Application Ref:	2026/0143			 Ribble Valley Borough Council www.ribblevalley.gov.uk				
Date Inspected:	26/03/2026	Site Notice:	26/03/2026					
Officer:	EP							
DELEGATED ITEM FILE REPORT:					APPROVAL

Development Description:	Proposed single storey detached garage.
Site Address/Location:	Bridge End Cottage, Rimington Lane, Rimington BB7 4EA.

Ground Floor Plan

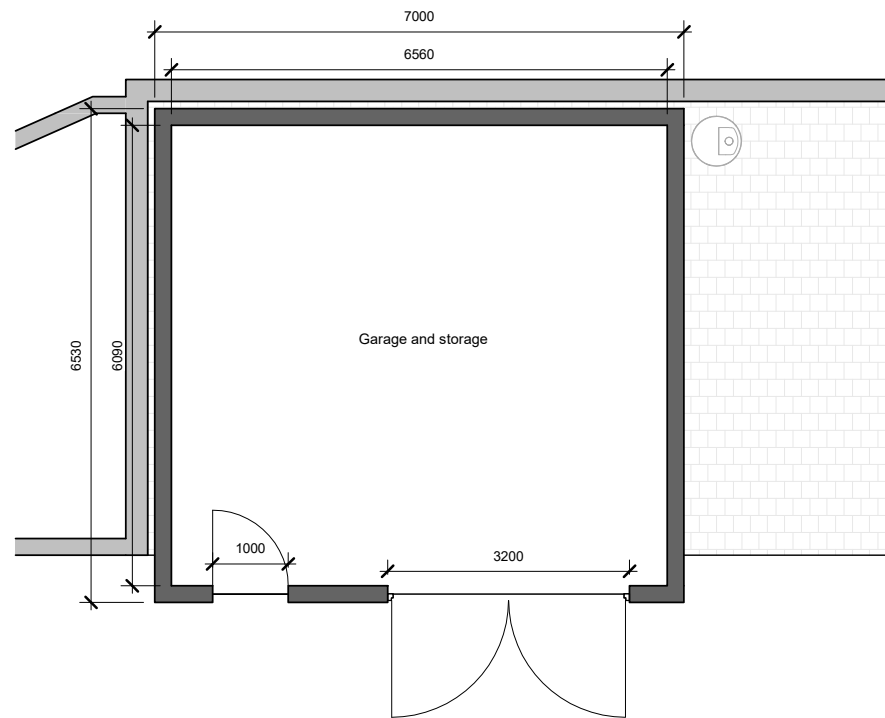
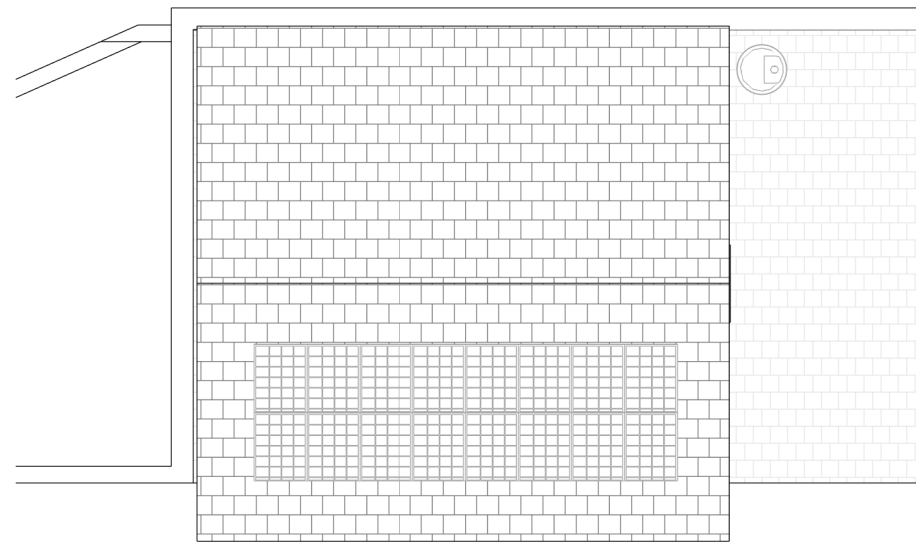
The proposed garage would measure 7m by 6.5m in length and width, which is only marginally larger in footprint than a standard double garage size. When read in relation to other built form within the vicinity, and when compared against the scale of the application dwelling itself, the garage would not appear over dominant within the site.

The proposed garage will be constructed in natural stone to the elevations, with a slate roof and timber garage doors. These materials are consistent with those found on the application and wider area and are appropriate to this context within the open countryside. The garage includes the addition of solar panels to the principal roof slope, these will be integrated into the roof and will therefore not be overly prominent.

DRAWING TITLE: PROPOSED DRAWINGS

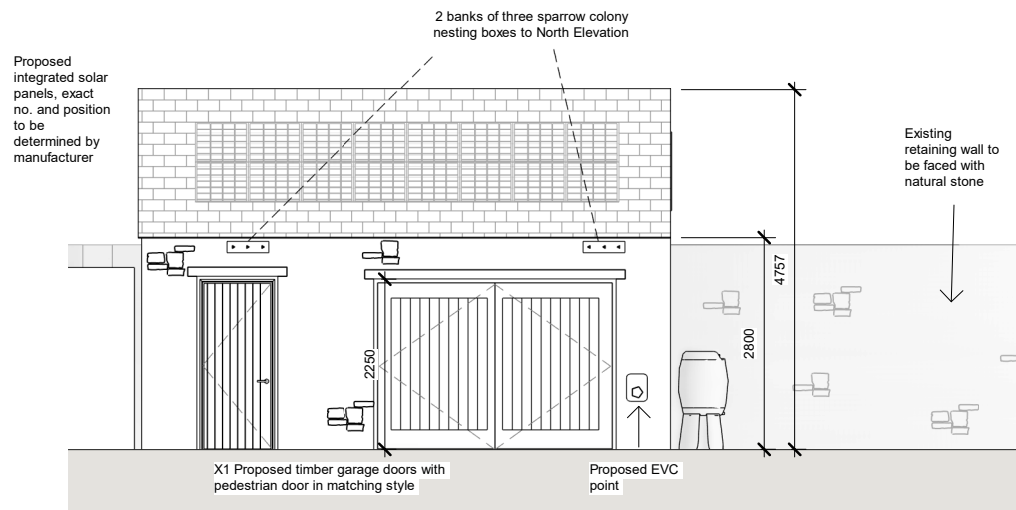
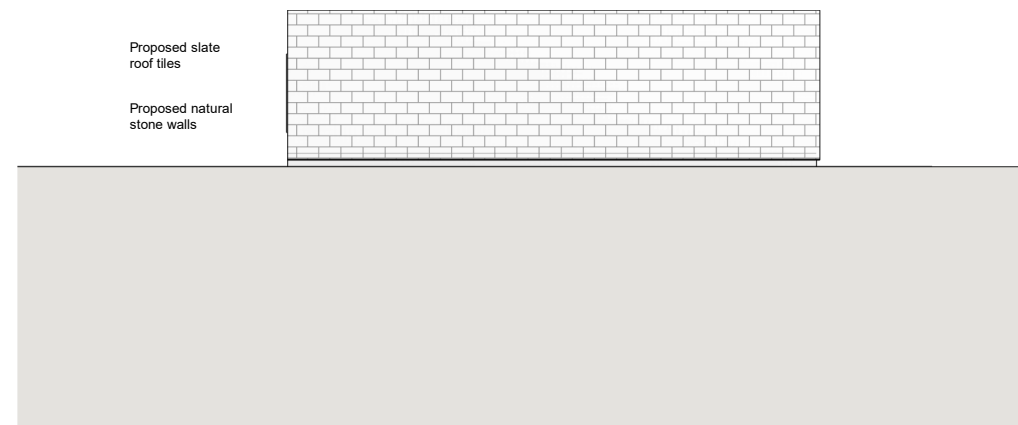
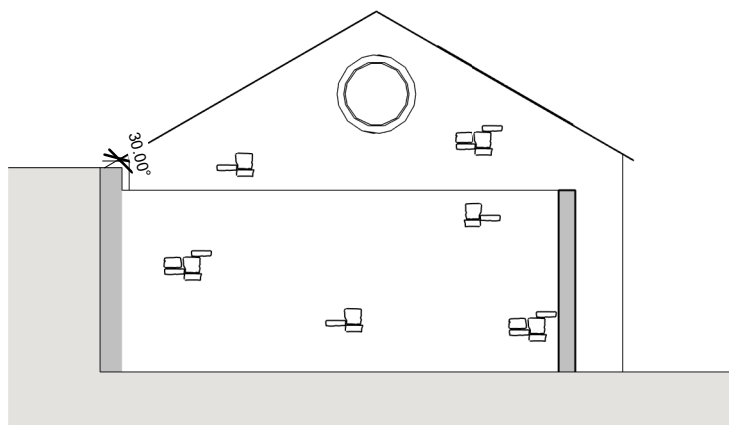
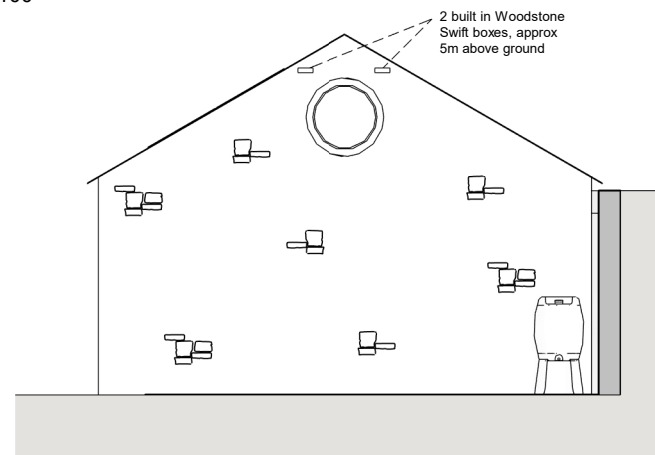
The ridge and eaves height of the garage is fairly modest measuring 2.8m and 4.75m respectively. When viewed against the backdrop of the existing retaining wall on site which accommodates a change in ground level, the garage would not appear prominent, with the eaves being a comparable height.

DRAWING TITLE: PROPOSED SITE PLAN

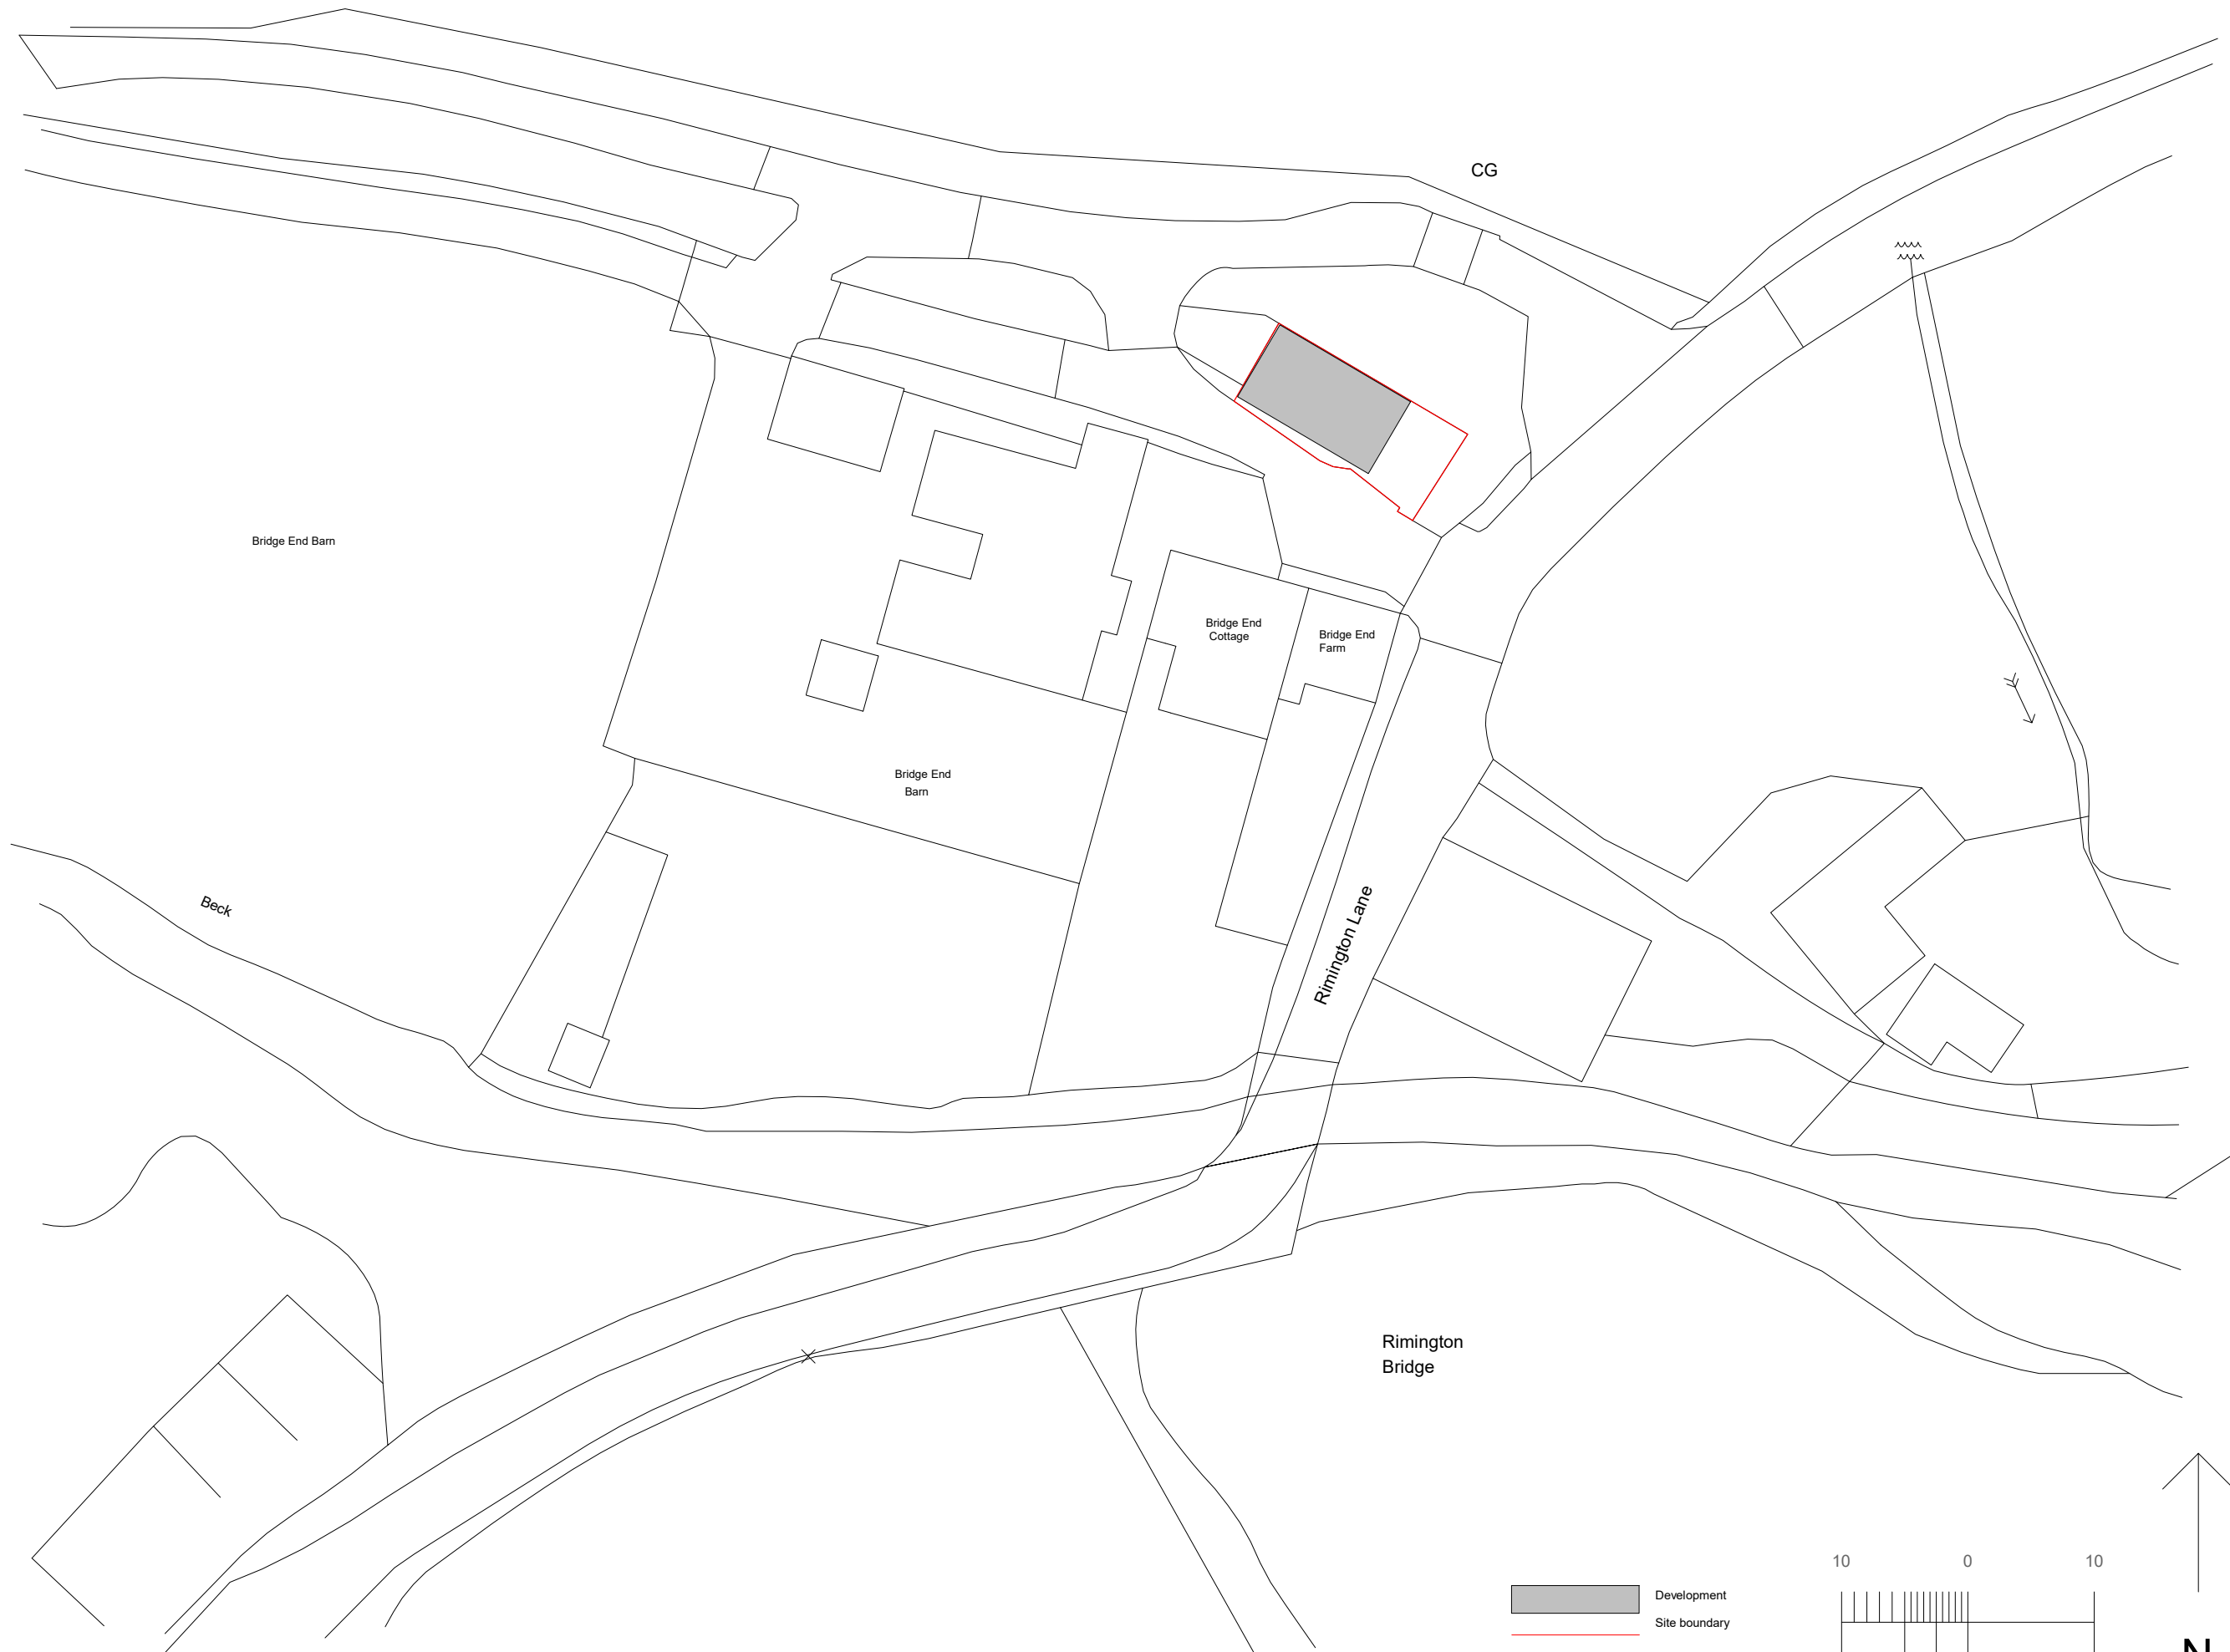
The proposed development would be sited to the northern extents of the site, in close proximity to Rimington Lane itself with a Public Right of Way footpath immediately adjacent to the development site. As a result, the proposed development would host a readily visible position from within the public realm.
